**Consultation Response from KC,  
Trees**

**2025/93108 Land at, Penistone Road, Fenay Bridge, Huddersfield, HD8 0AS**

**Demolition of existing stables and erection of detached dwelling**

**Date Responded: 10/12/2025**

SITE PLAN SCALE 1:250

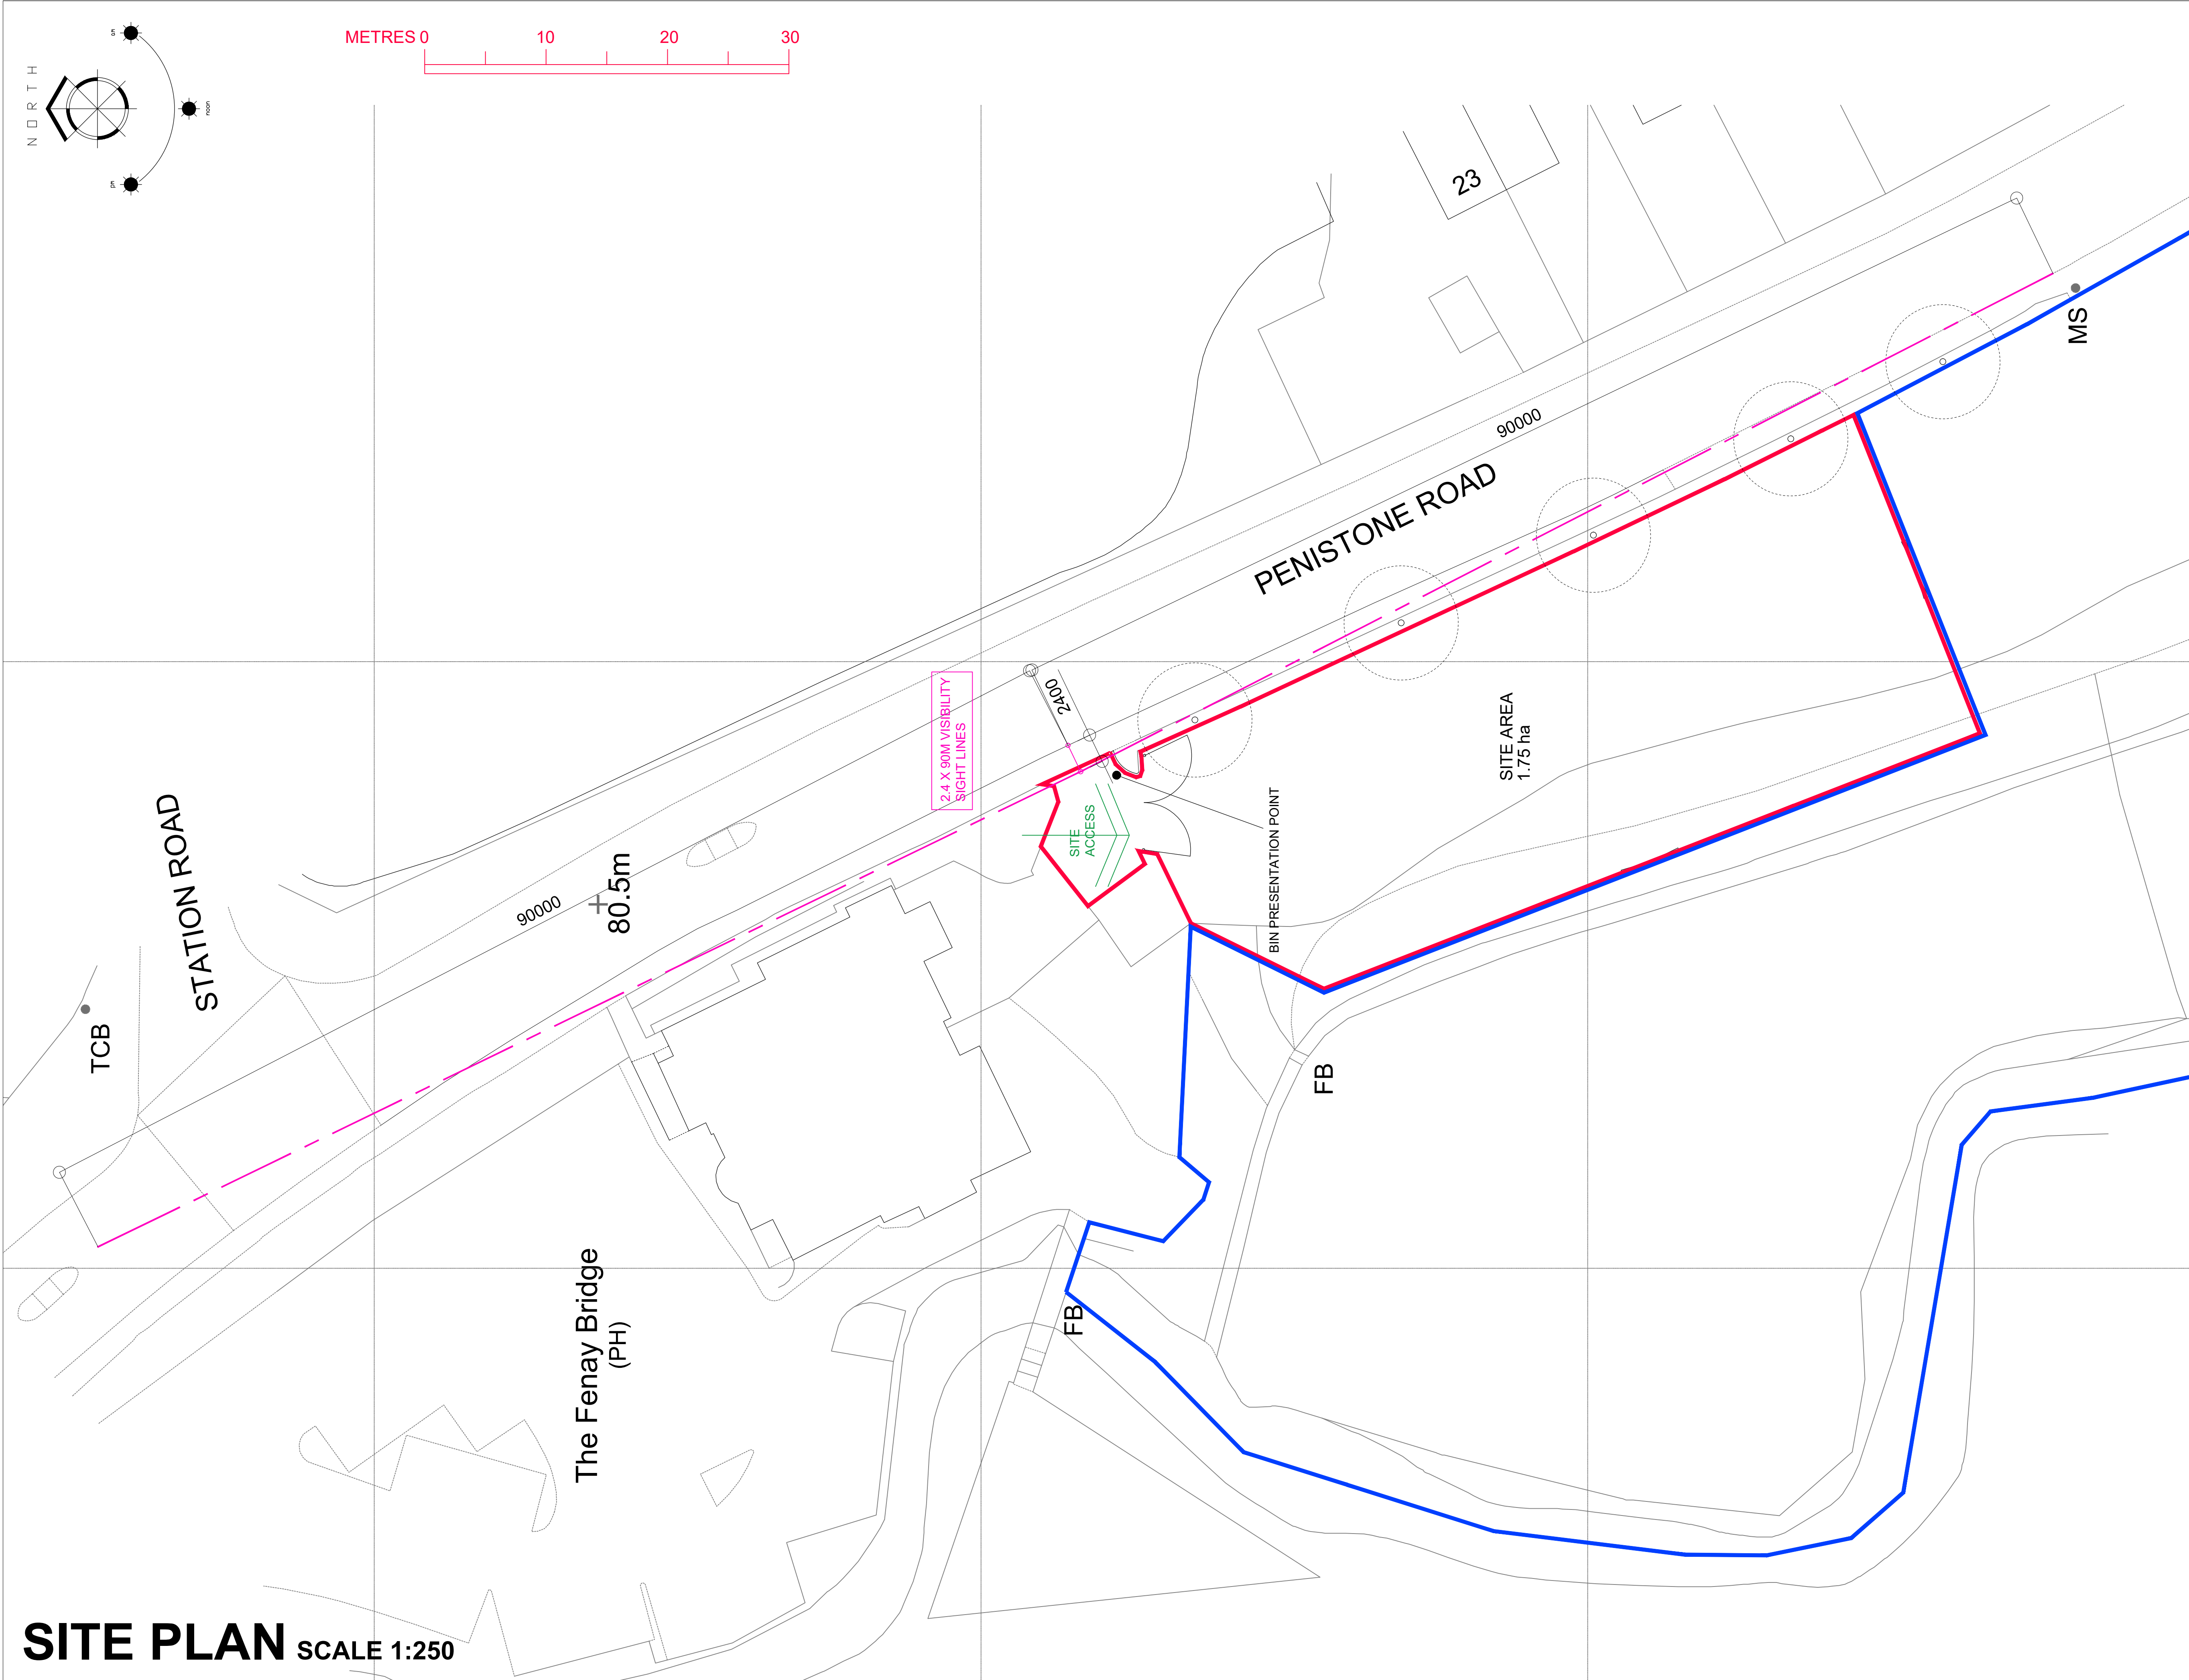
Due to the proximity of the trees on the boundary to Peniston Road there would need to be an Arboricultural Impact Assessment (AIA) submitted so that the neighbouring trees Root Protection Area's (RPA's) can be calculated and if any impact is present to these trees.

The driveway and eastern aspect of the property look to be within the RPA's of these trees.

The proposals may be achievable, but the AIA will show whether any special engineering would be required should the proposals protrude into any RPA's.
